Project #: 1004677 Application #: 13DRB-70737/13DRB-70738/13DRB-70740

Project Name: Country Plaza Subdivision

**CITY OF ALBUQUERQUE
PLANNING DEPARTMENT
November 6, 2013
DRB Comments**

RE: Lots 1-5, Country Club Plaza

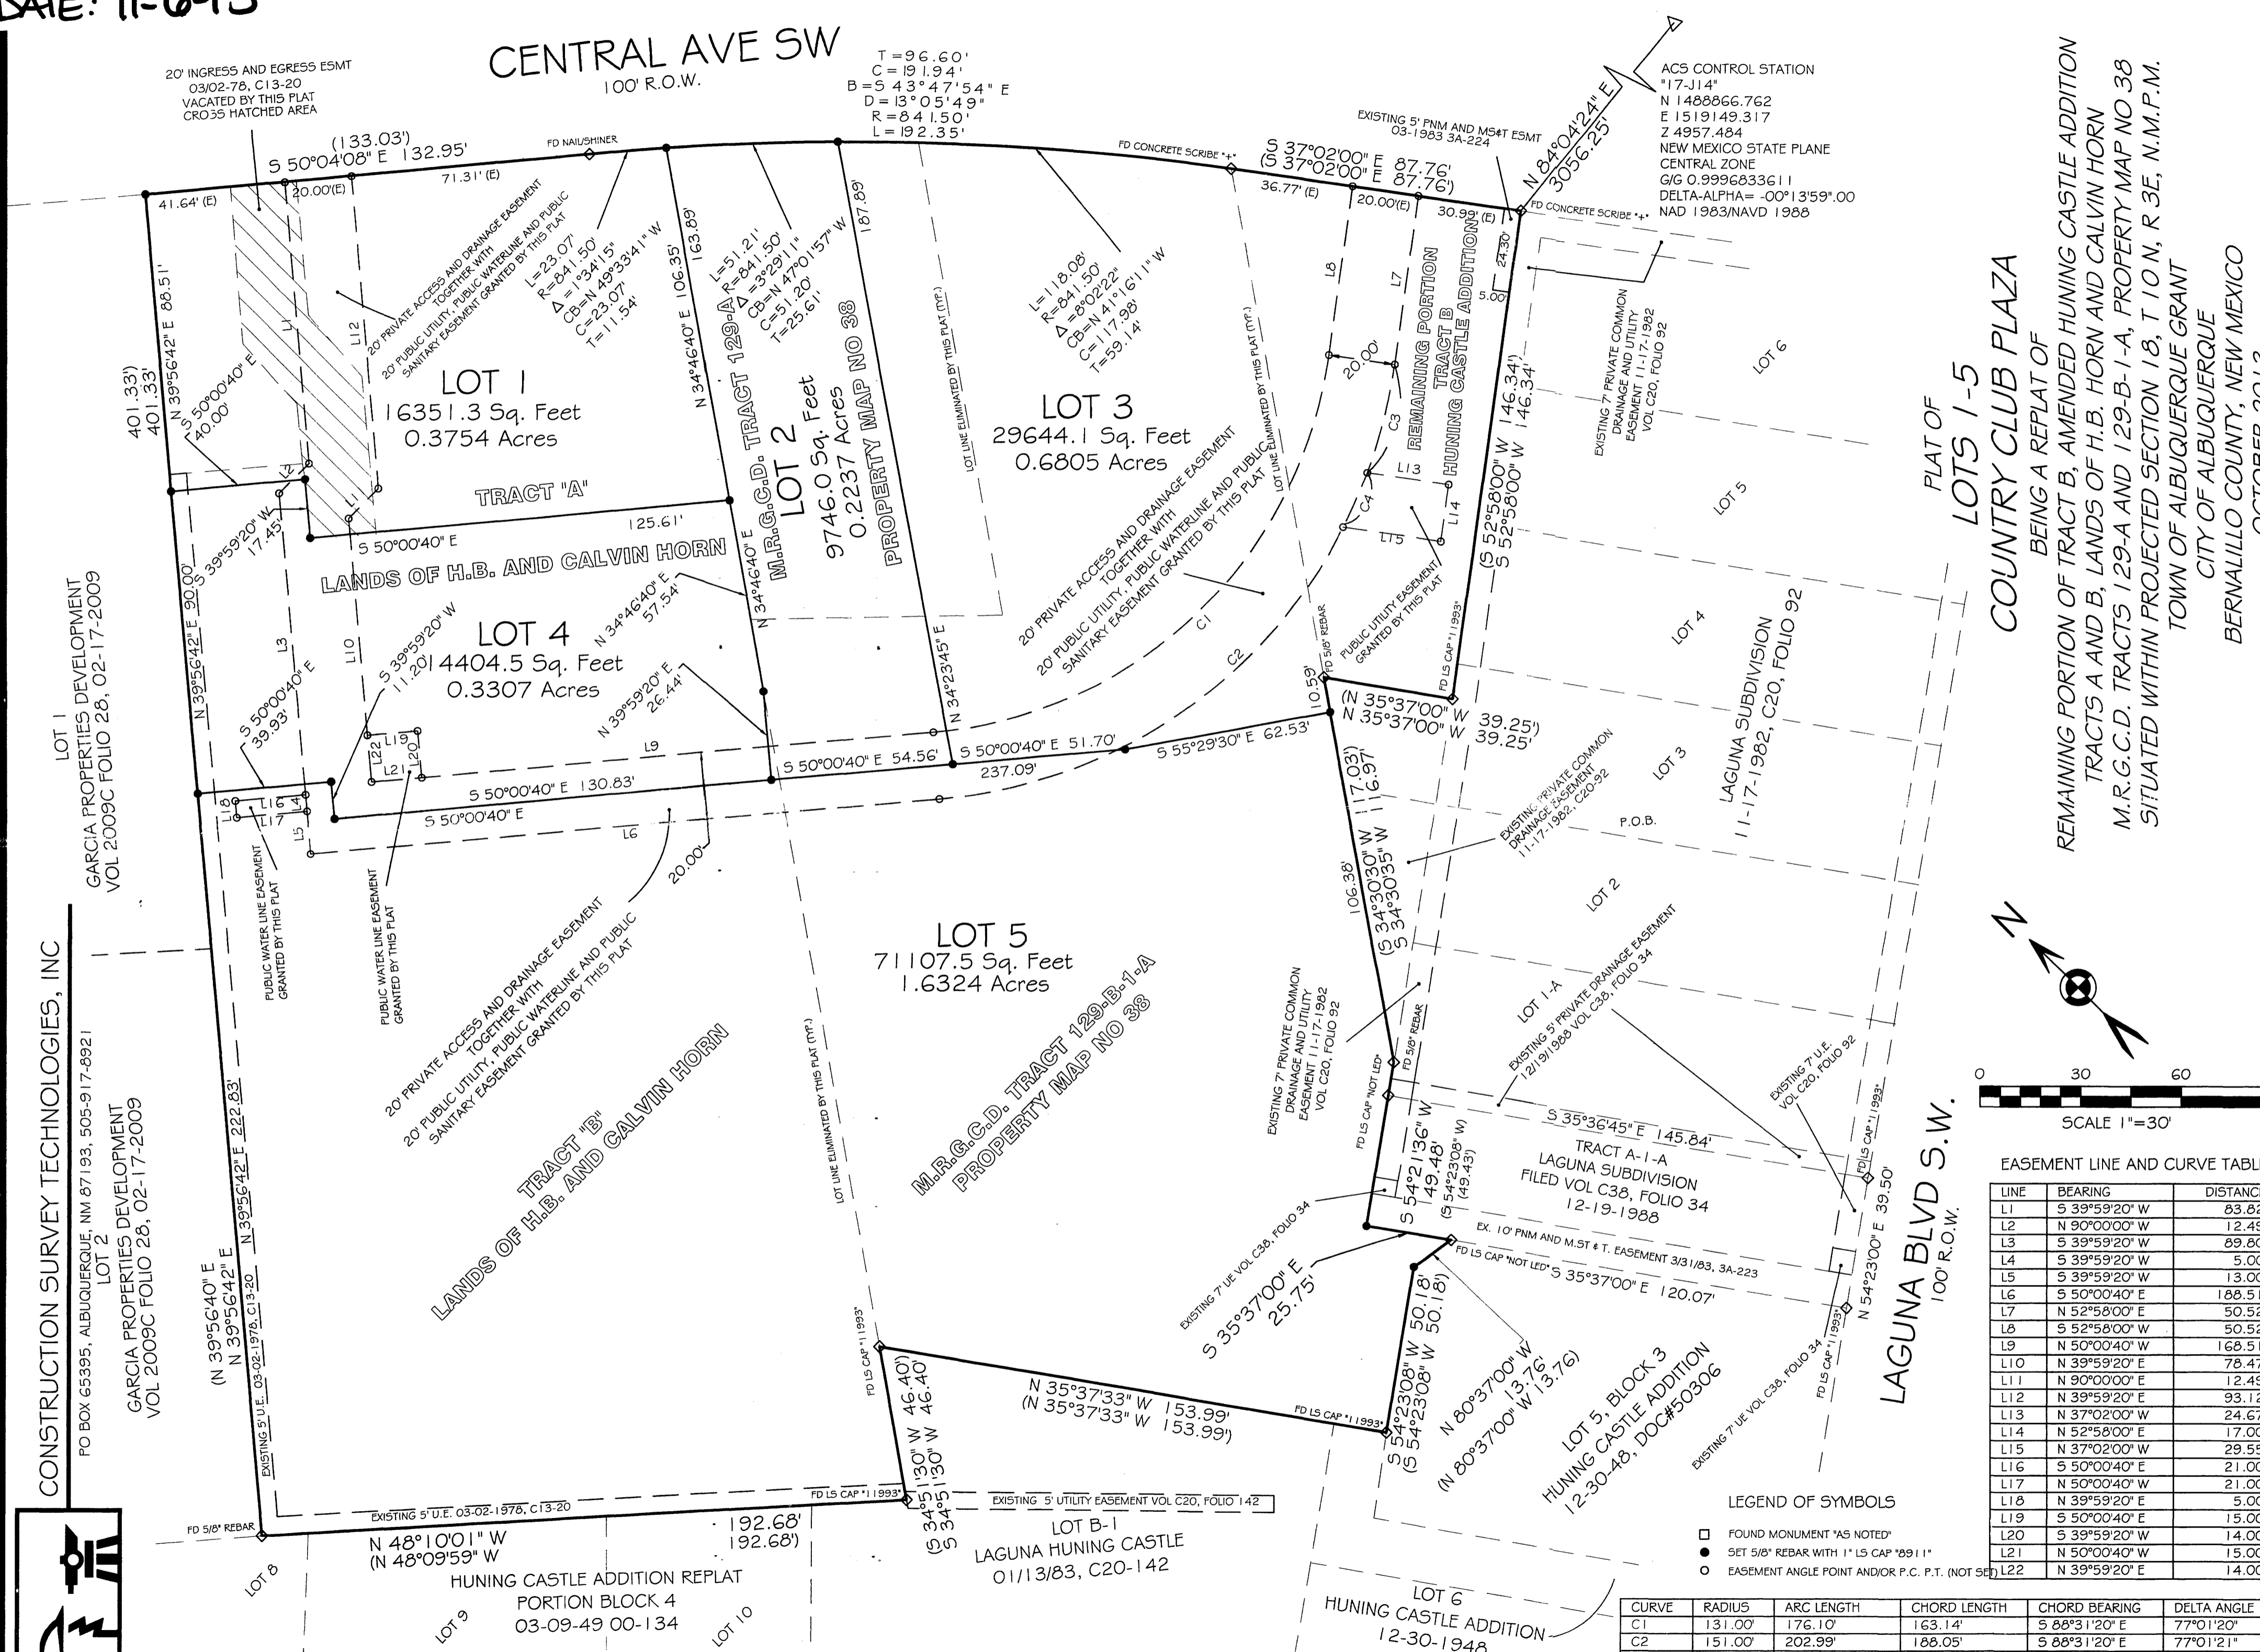
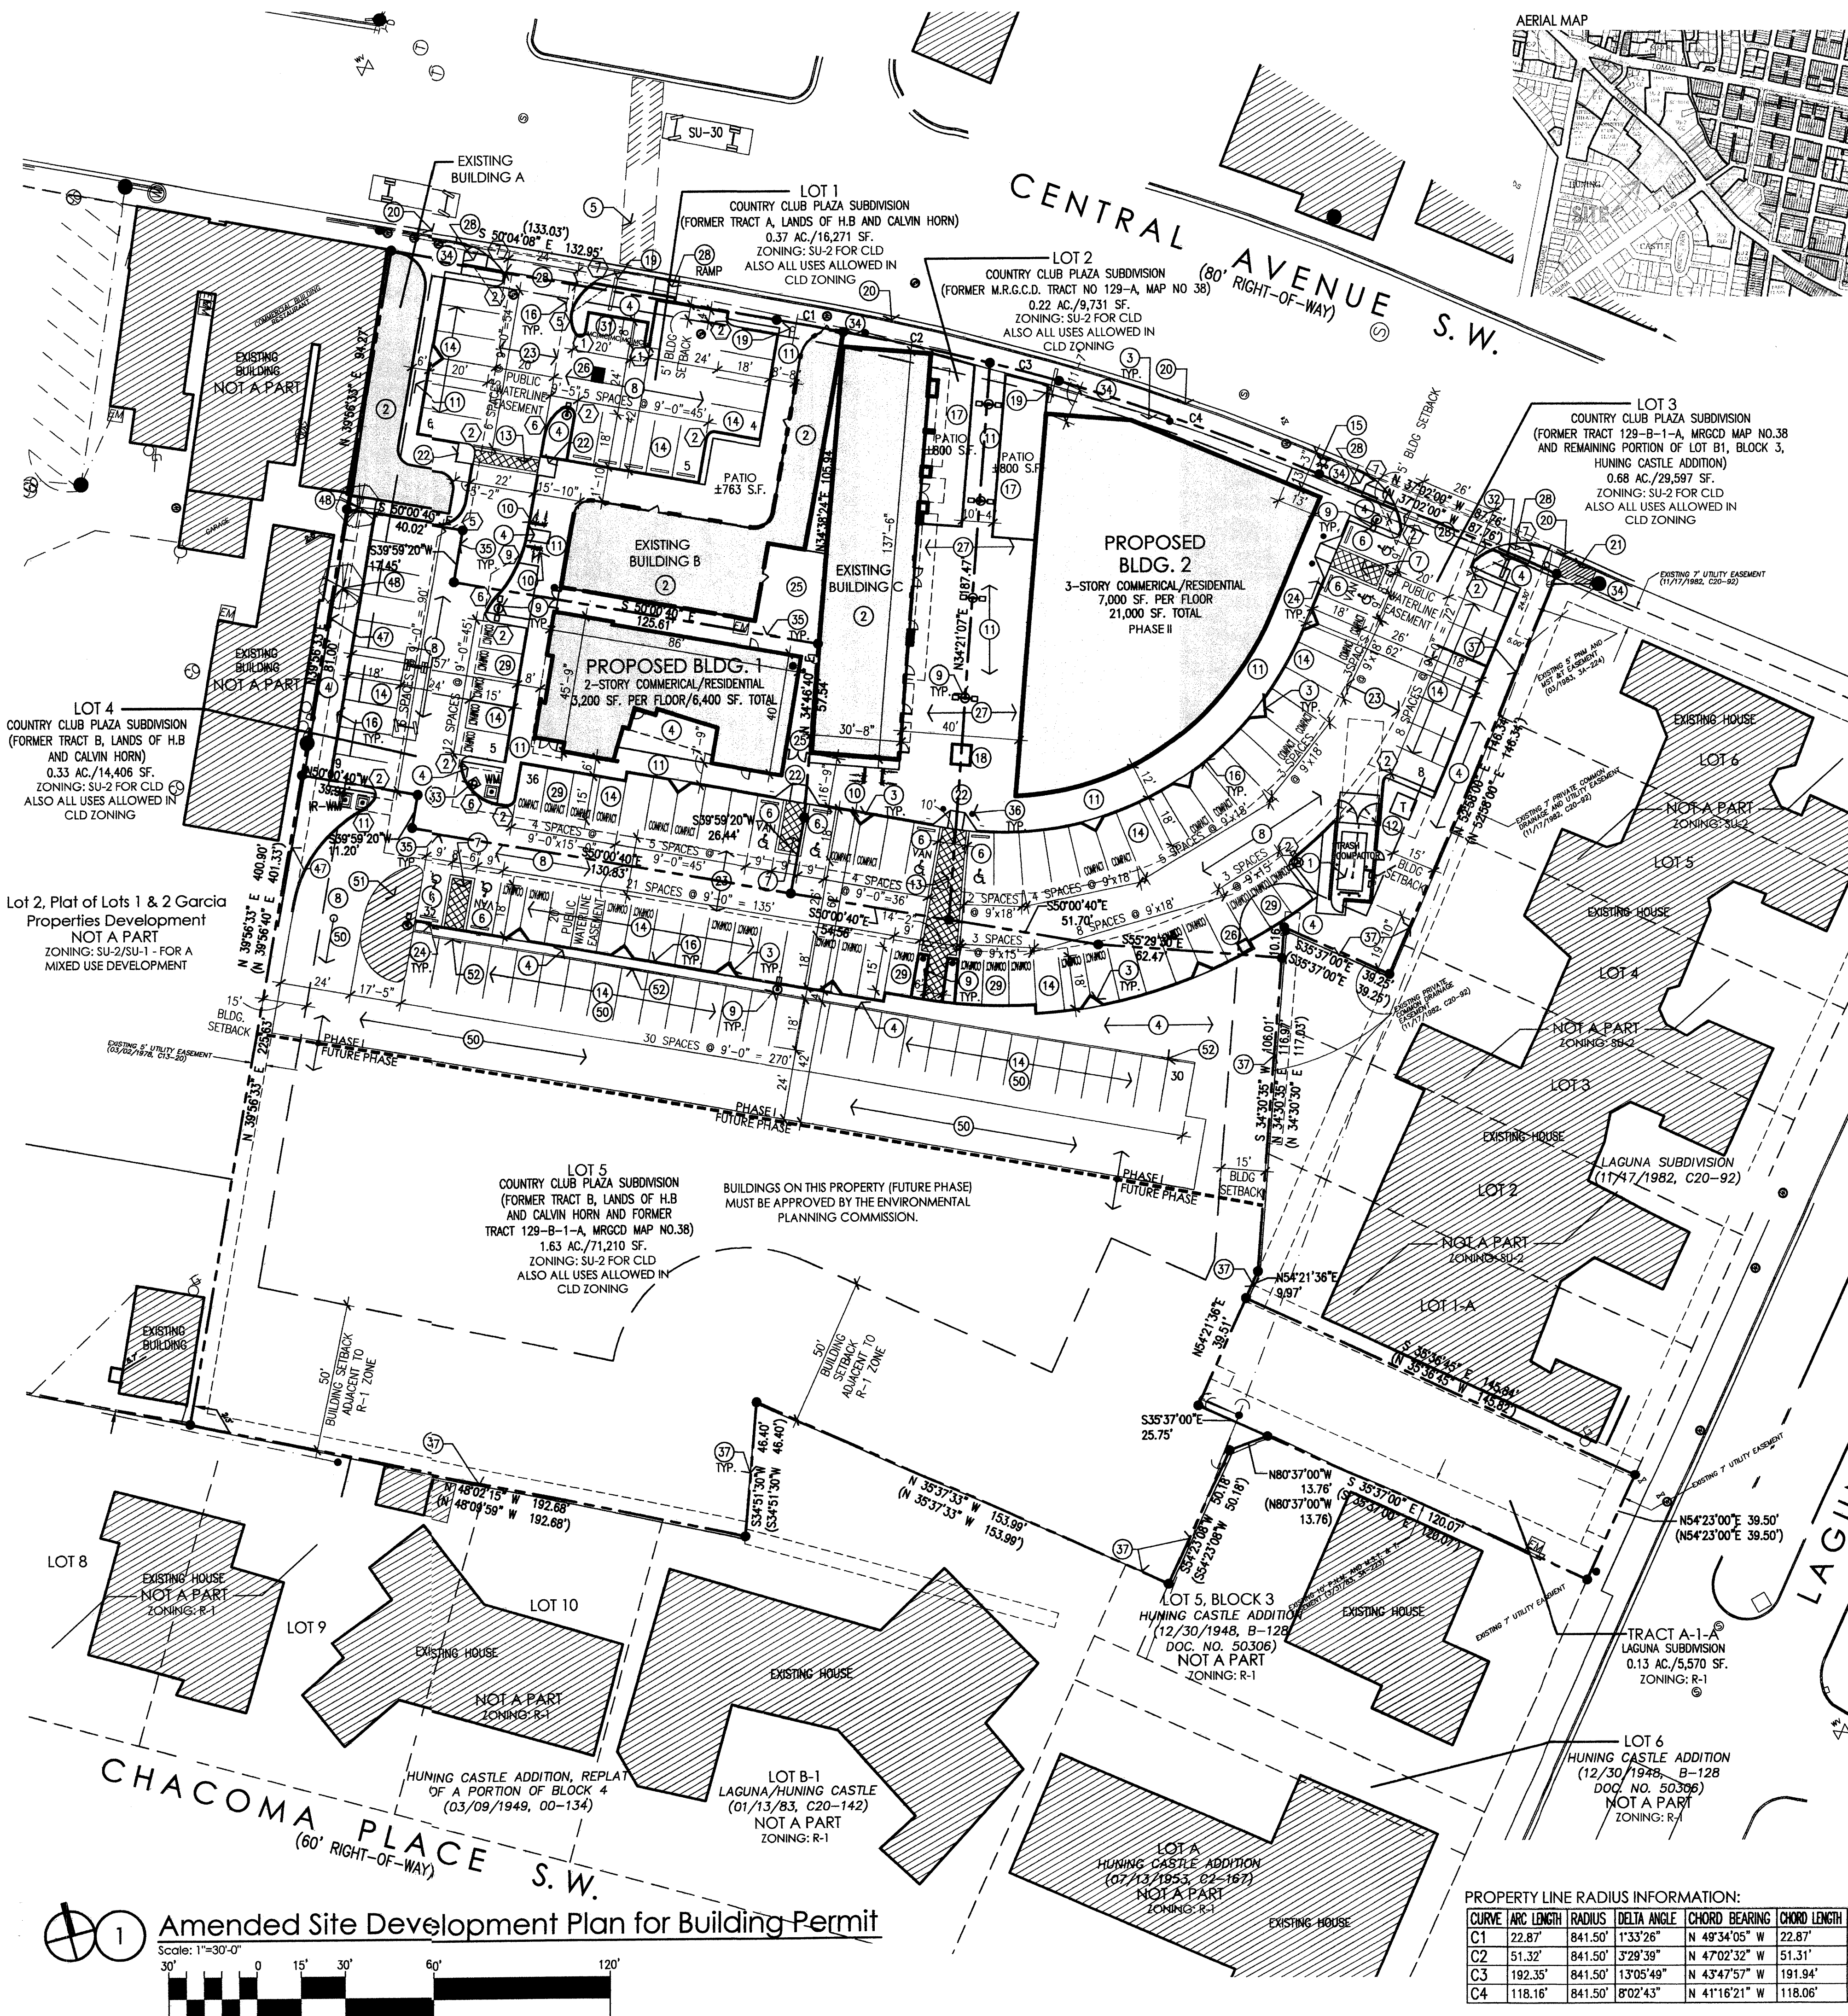
Vacation of a private easement requires a separate application and written acknowledgement from all the beneficiaries of the easement that they specifically agree to the vacation.

Based on approved site development plan, reciprocal parking easements are needed; also the building setback for Lot 5 should be shown on the plat.
